A47 Wansford to Sutton Dualling

Scheme Number: TR010039

Volume 9 **9.35 Environmental Statement Addendum** **One**

**9.35 ENVIRONMENTAL STATEMENT
ADDENDUM ONE**

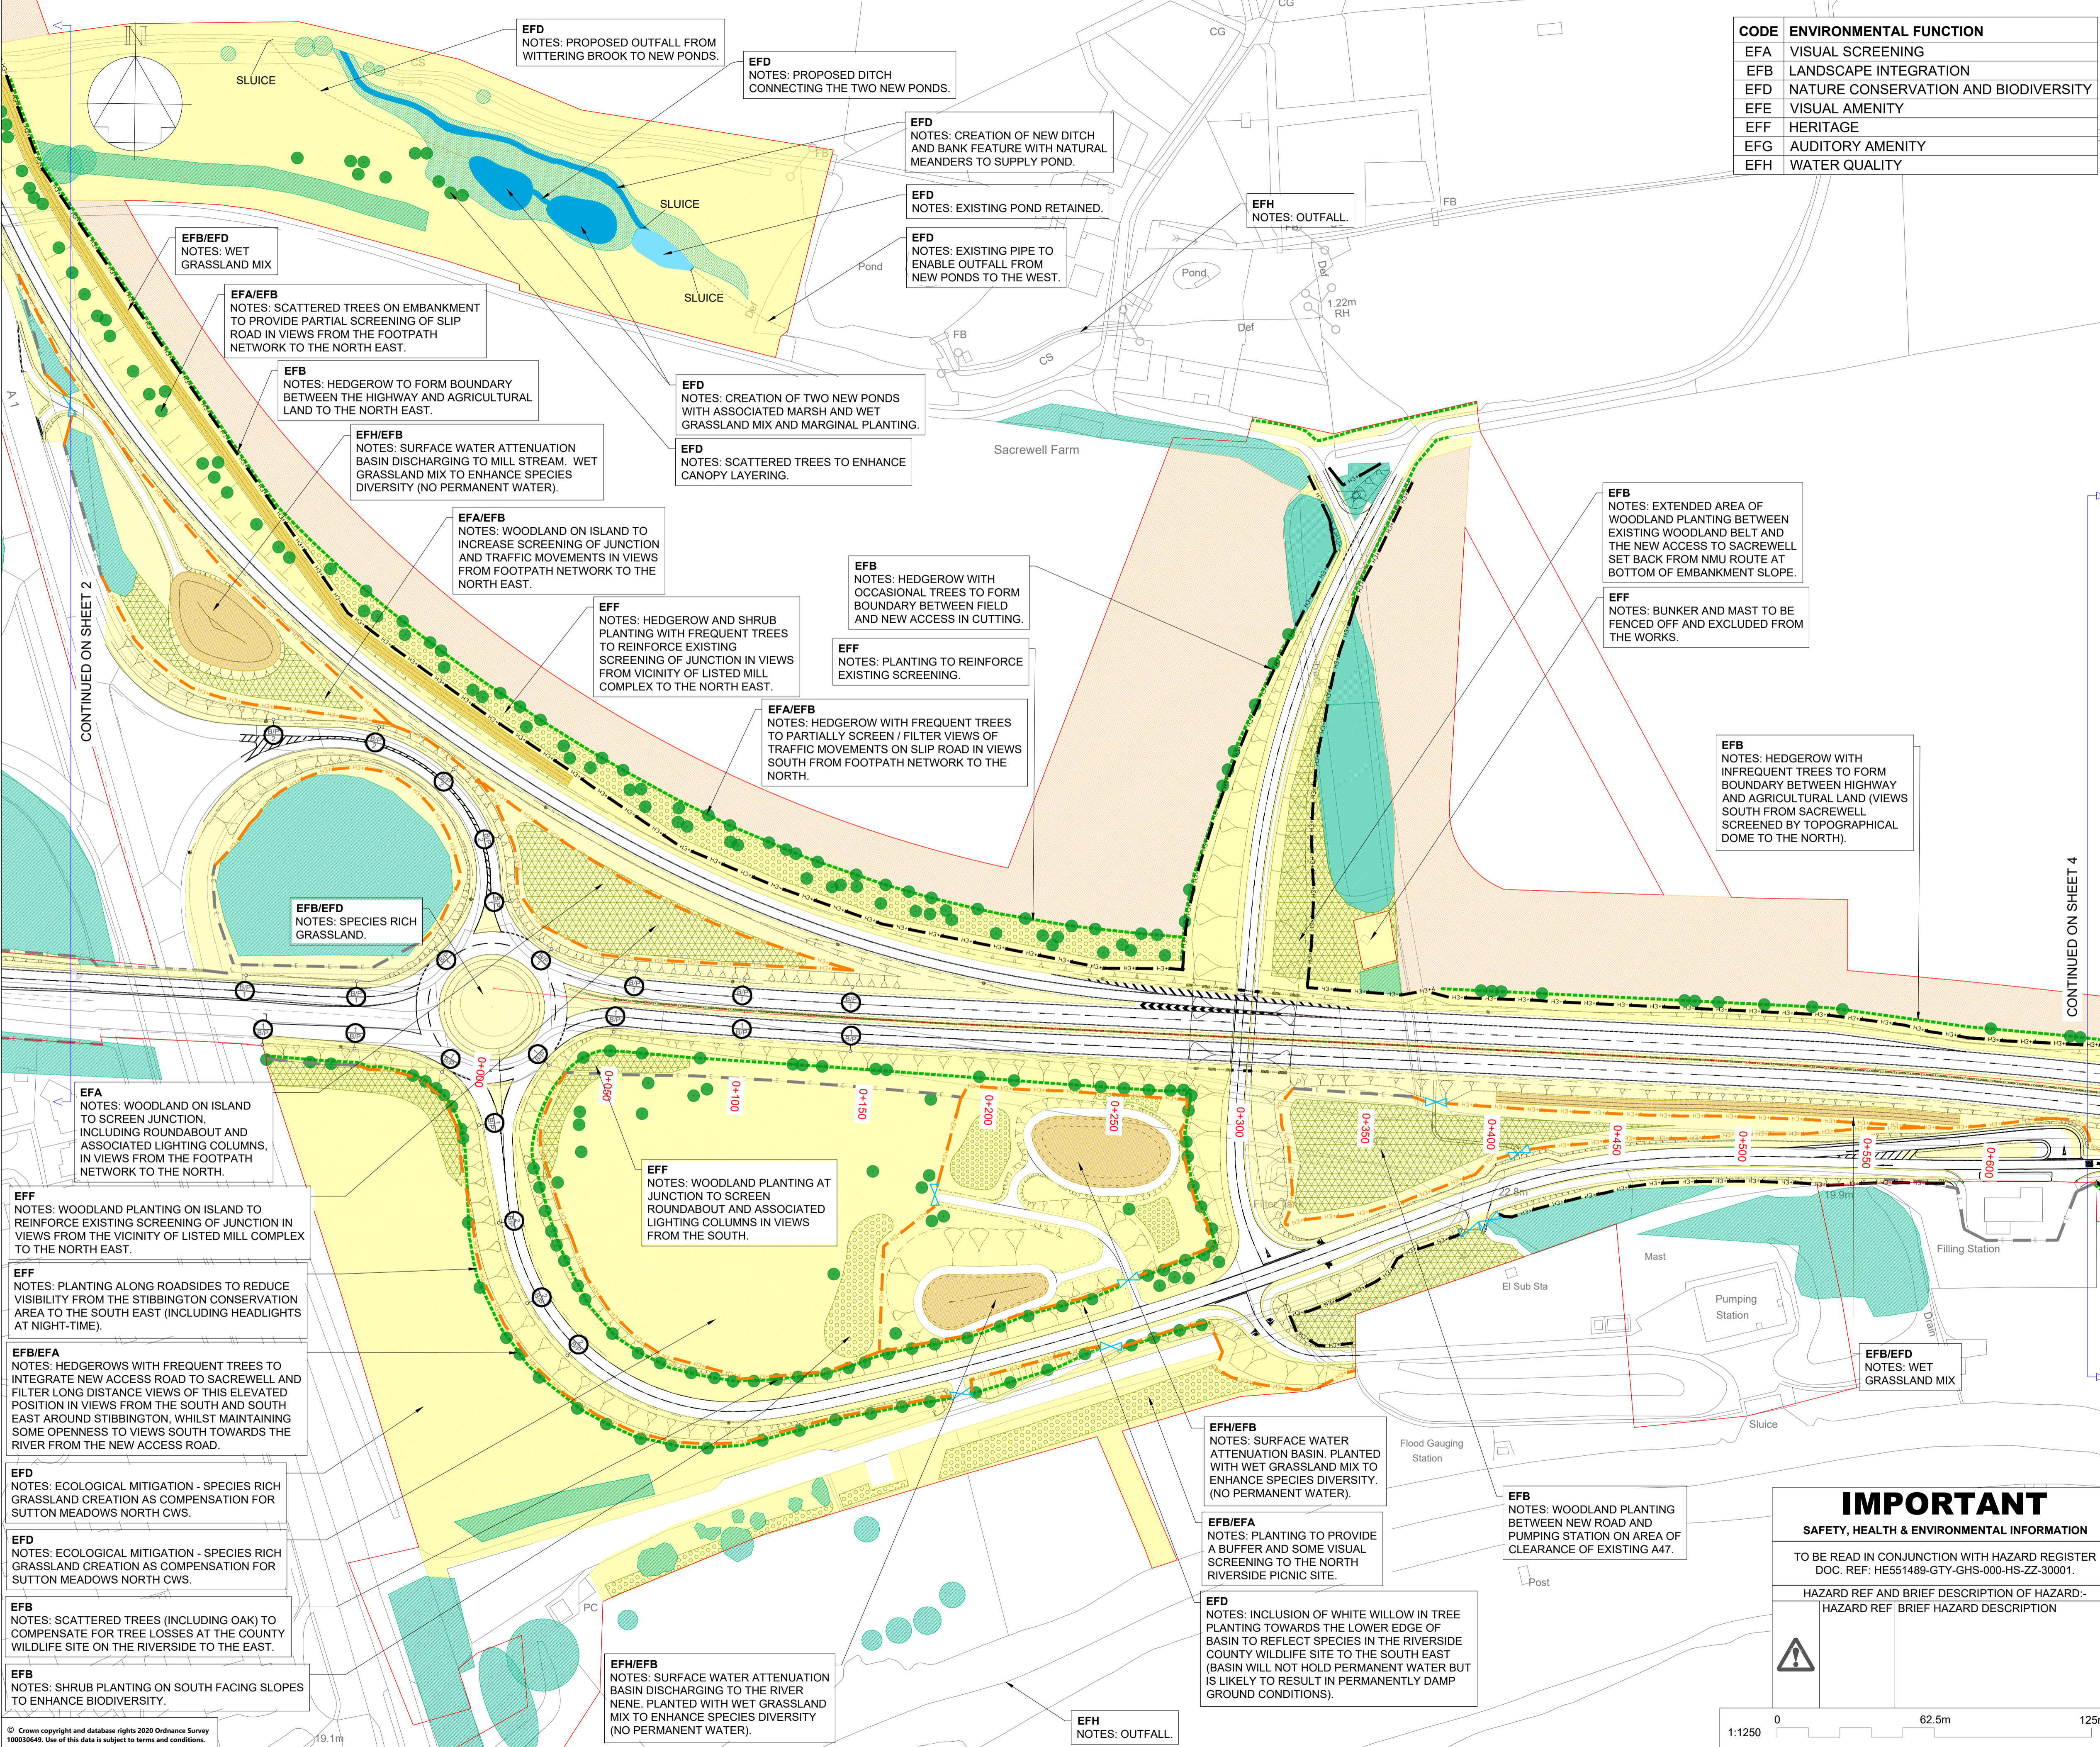
- 2.2.1. The Applicant has carried out a detailed review of the construction phasing requirements associated with utility diversions in this location and proposes to move the westbound off-slip (Work no. 15) 14 m to the north. The purpose of this proposed change is to achieve a more efficient interface between the Scheme and assets belonging to Anglian Water, Western Power Distribution, Gigaclear, Openreach, Vodafone and GTT.
- 2.2.2. The findings and conclusions of each ES Chapter are to be reviewed against this design change to determine whether there are no new or different likely significant effects than those previously reported in the ES due to this design change.
- 2.2.3. This design change is illustrated in the Environmental Masterplan Rev 3 [TR010039/APP/6.8 Rev 3].

DRAWING NUMBER
HE551494-GTY-ELS-000-DR-LE-33004

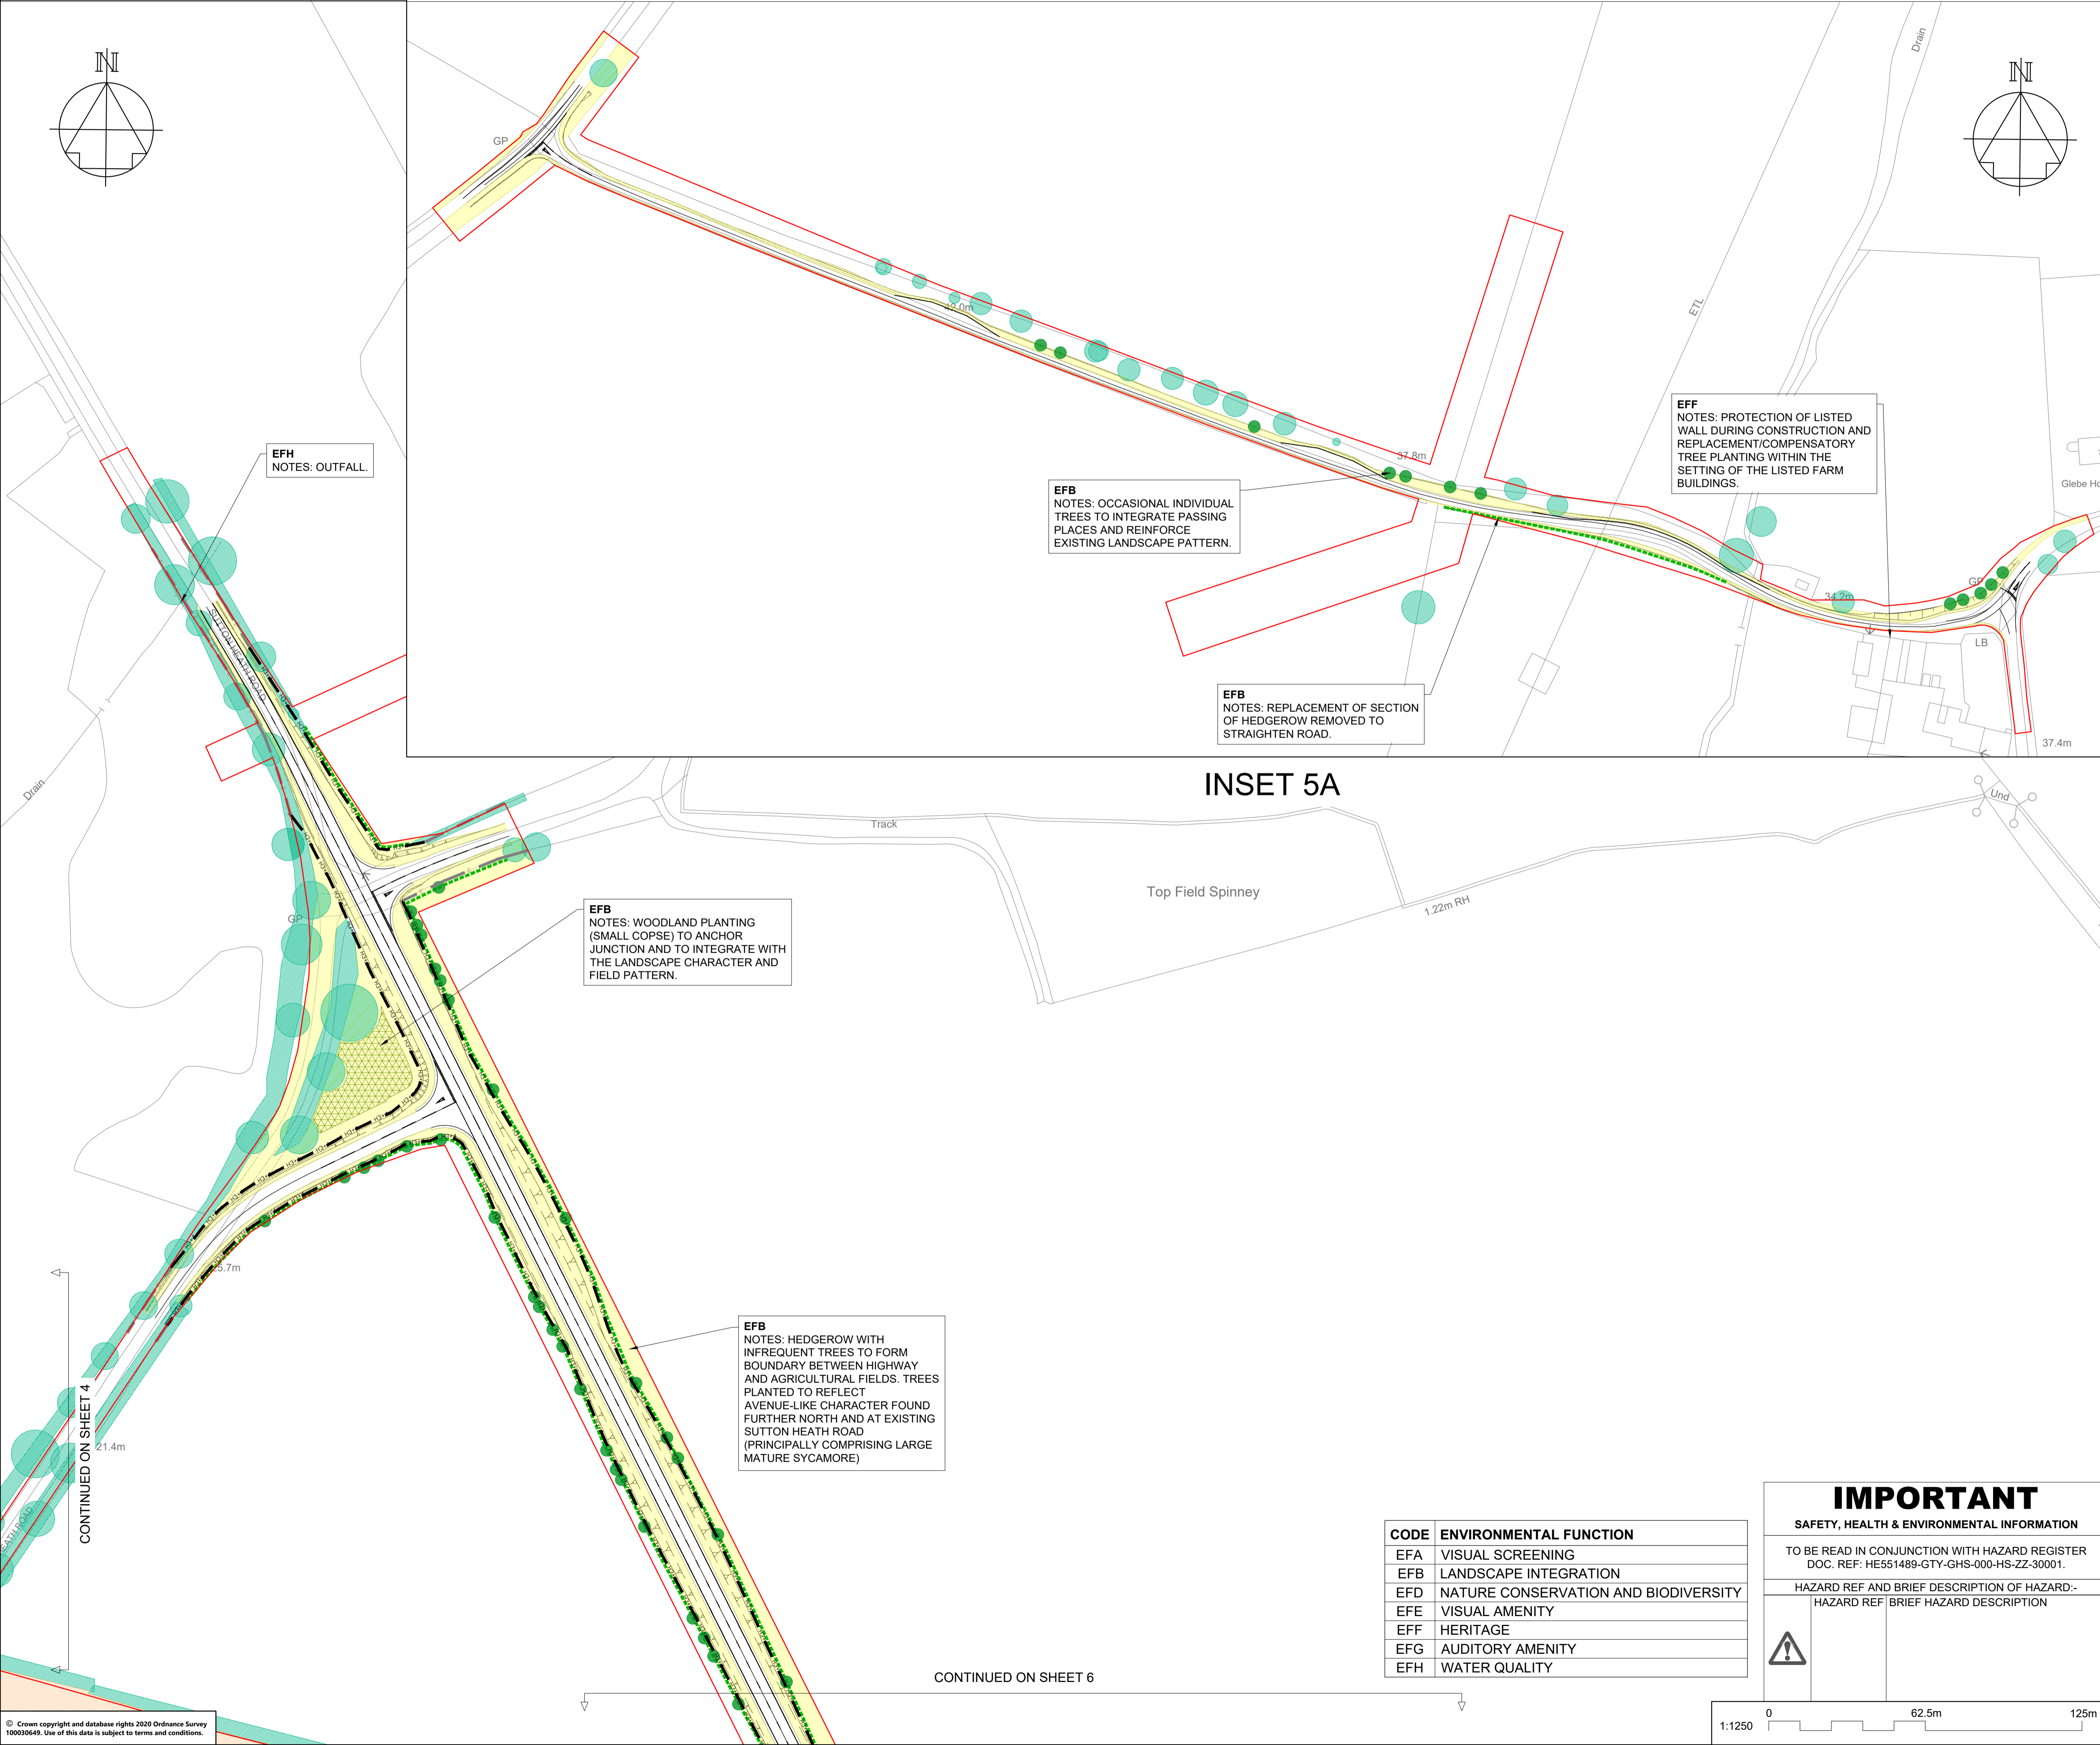
- 2.3.1. The Applicant proposes to modify the access alignment for the following reasons:
 - a) to improve visibility (and to obviate the need for convex mirrors)
 - b) to respond to the Examining Authority's (Hearing Action Point 38 [EV-021])

- c) to avoid interface with the Anglian Water assets shown on the Environmental Masterplan [TR010039/APP/6.8 Rev 3]

- 2.3.2. The change will result in a more efficient design, taking into account objectives (a) to (c) above.
- 2.3.3. The proposed modification will consist of changes to the alignment of the access to Sacrewell Farm as shown on the Environmental Masterplan [TR010039/APP/6.8 Rev 3].
- 2.3.4. The findings and conclusions of each ES Chapter are to be reviewed against this design change to determine whether there are no new or different likely significant effects than those previously reported in the ES due to this design change.
- 2.3.5. This design change is illustrated in the Environmental Masterplan Rev 3 [TR010039/APP/6.8 Rev 3].

- 3.4.5. The change to the alignment of the proposed new access road into Sacrewell Farm would introduce a gently curving alignment in cutting which would pass through the existing woodland belt which lies to the west of the existing access road into Sacrewell Farm.

3.4.11. The Design Change Two proposed alternate layout for Scarewell Road however, does have implications for the extent of tree retention and tree removal detailed within ES Appendix 7.6: Arboricultural Impact Assessment [REP4-007]. The vegetation affected by the proposed amendment comprises four groups of trees recorded as G10, G11, G12 and G13 within ES Appendix 7.6: Arboricultural Impact Assessment [REP4-007]

3.4.12. With respect to G10 this feature was assessed as being of a high retention value (BS5837:2012 Category A) and the initial proposal required the removal of a section of the group totalling approximately 307 m² in area. The amended

proposal will permit the full retention of this group with no impact upon the retained trees.

- 3.4.13. With respect to G11 this feature was assessed as being of a low retention value (Category C) and the initial proposal required the removal of a section of approximately 79 m² in area. The revised proposal will reduce the extent of vegetation requiring removal within this group to approximately 20 m².

- 3.4.14. G12, which has an overall area of approximately 1938 m², was assessed as being of a moderate retention value (Category B) and initial proposals required the removal of approximately 314 m² of vegetation from the edge of the group, the amended proposal will increase the extent of tree removal required to approximately 787 m² and clearance works will now bisect the group rather than only affecting the edge of the group.

- 3.4.15. G13, which has an overall area of approximately 2136 m², was also assessed as being of a moderate retention value (Category B) and is of a similar nature to G12. This group was not impacted by the original proposal and was identified for full retention. The amended proposal will require the removal of approximately 72 m² of the group.
